Redevelopment of Sydney Fish Market

56-60 Pyrmont Bridge Road, Pyrmont NSW

Response to Environmental Assessment Submissions

MP10_0060

DRAWING TITLE  
**TREE INVENTORY PLAN**

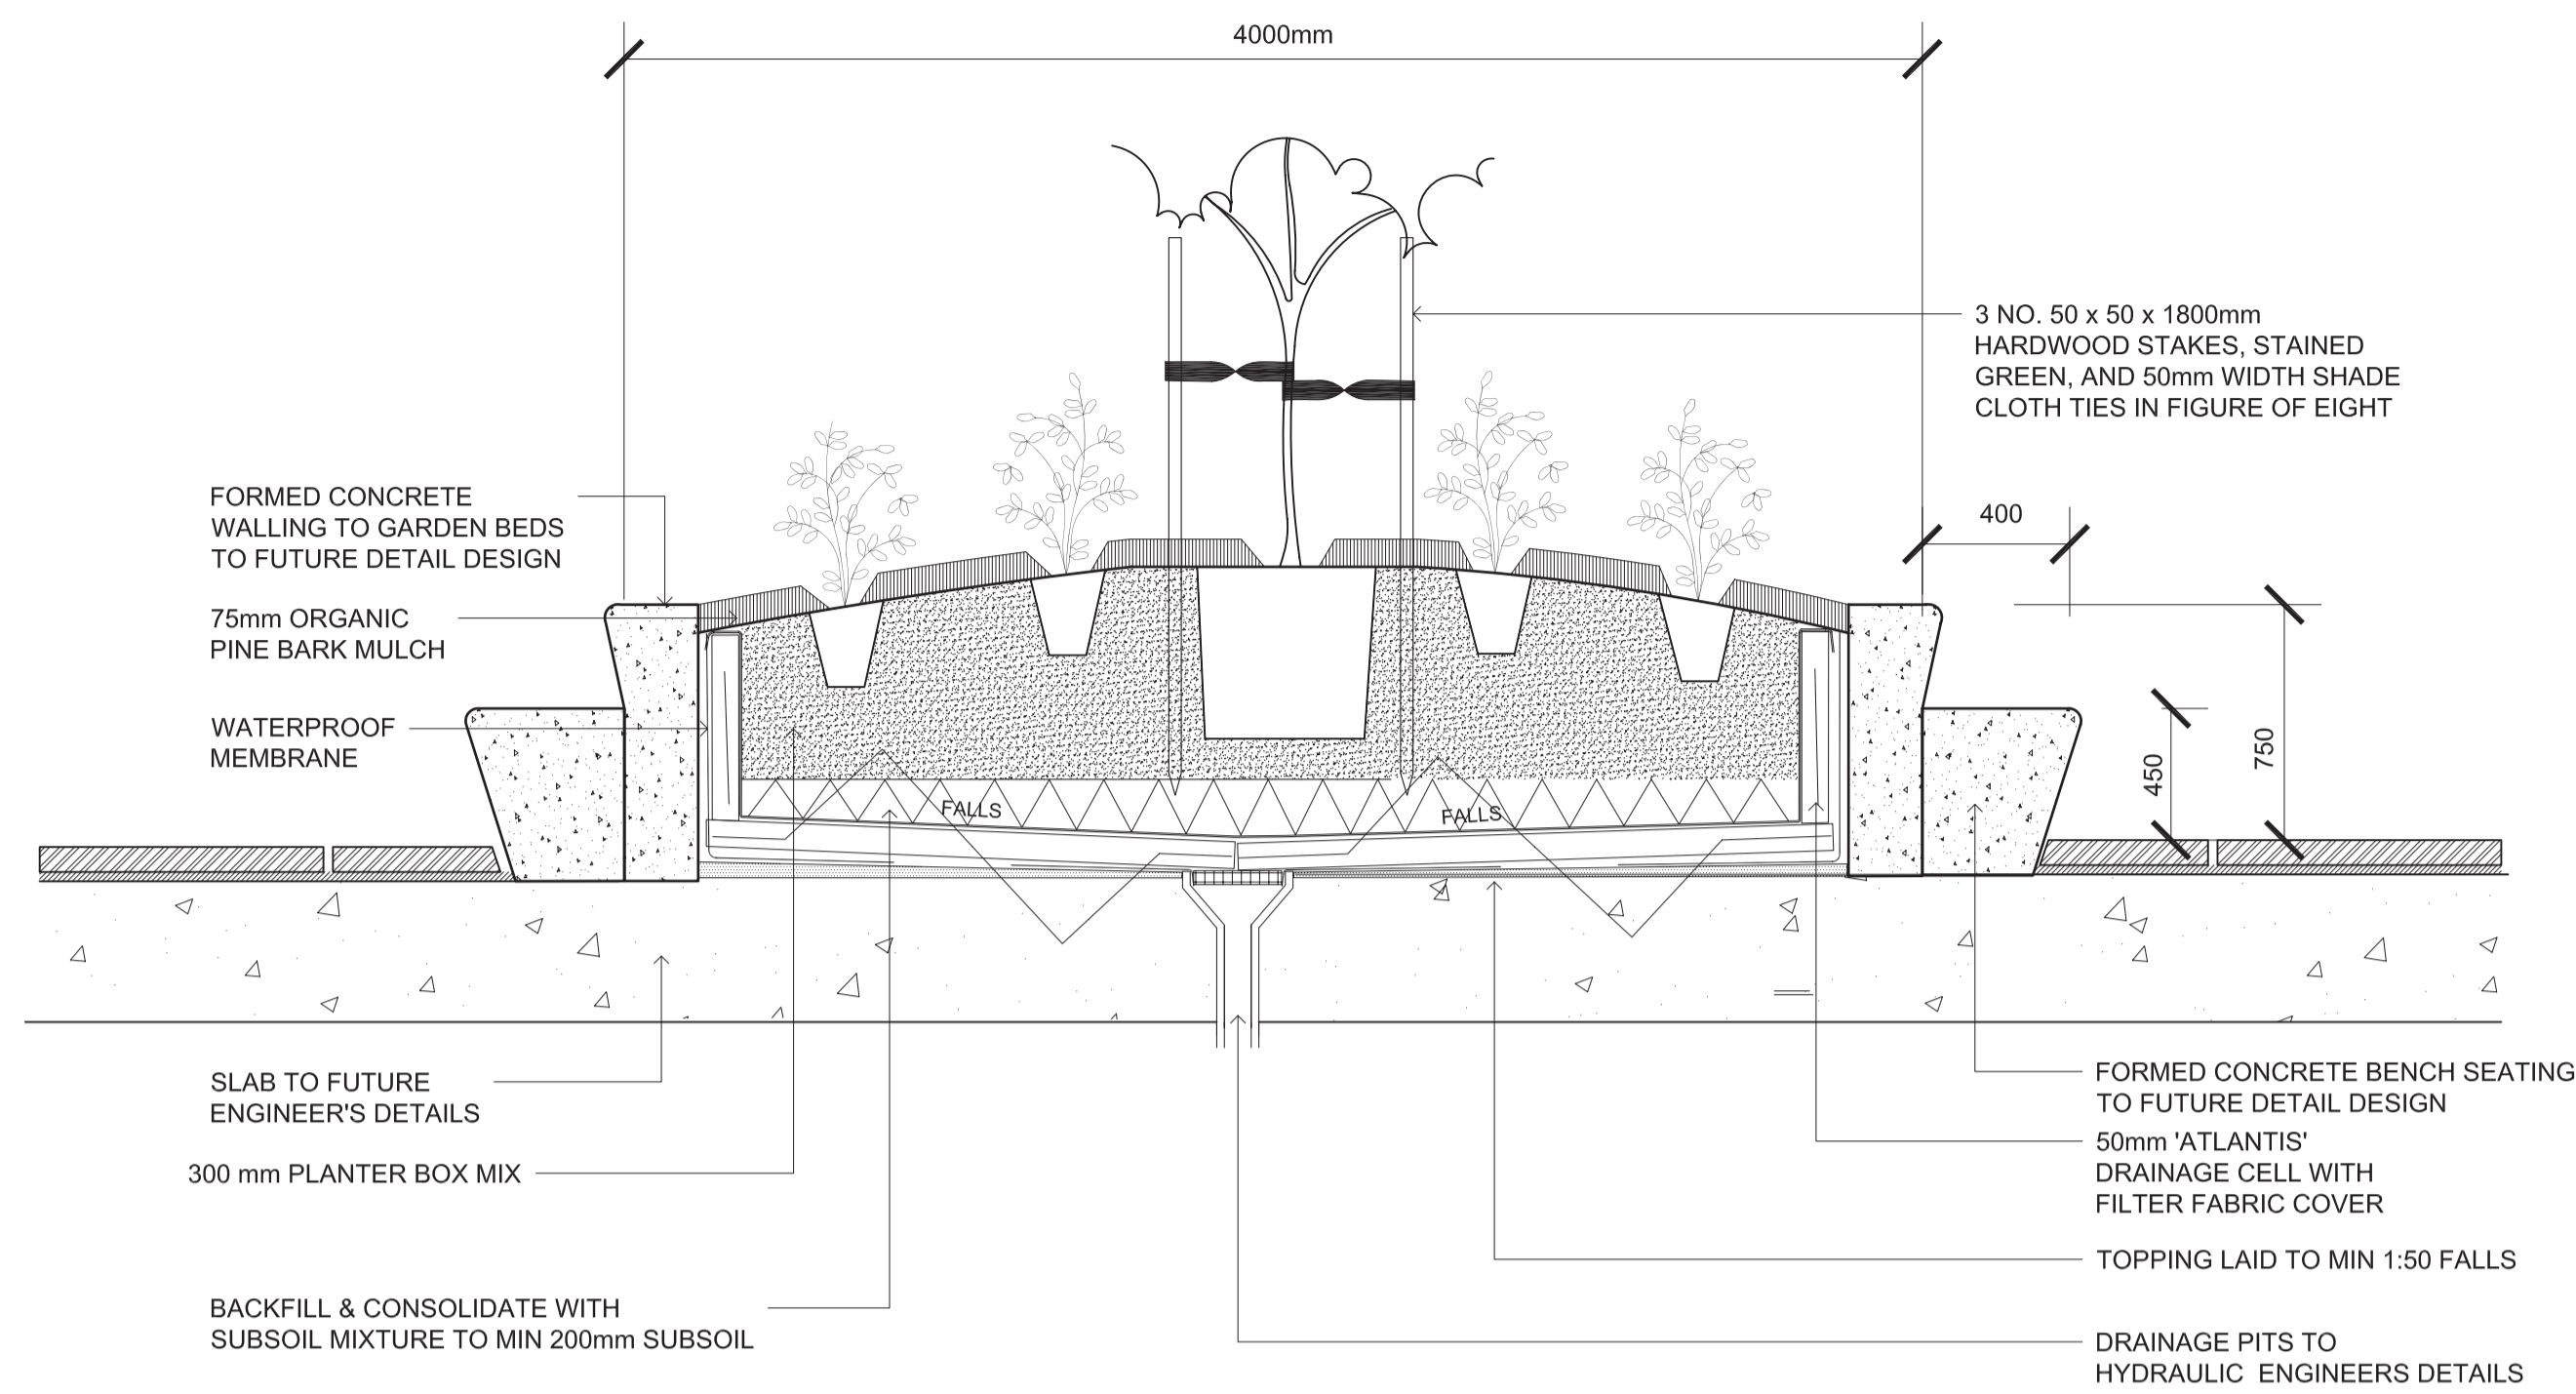
Whilst some of the trees at Jones Street, along the eastern side of the site, have been recommended to be retained, a number of trees are impacted by proposed Building A, the internal roadway and vehicular circulation of the SFM site, as well as being of poor form, branch overhang and ongoing root infrastructure issues. Deviation of the road alignment for tree retention is not possible due to the location of the support columns of the Western Distributor.

Where possible, trees along the eastern side of the site have been reviewed and retained, with the retention of two Hill's figs at the south-eastern portion of the site: tree numbers 15 and 16.

Refer to Revised Landscape Drawings (Appendix 3).
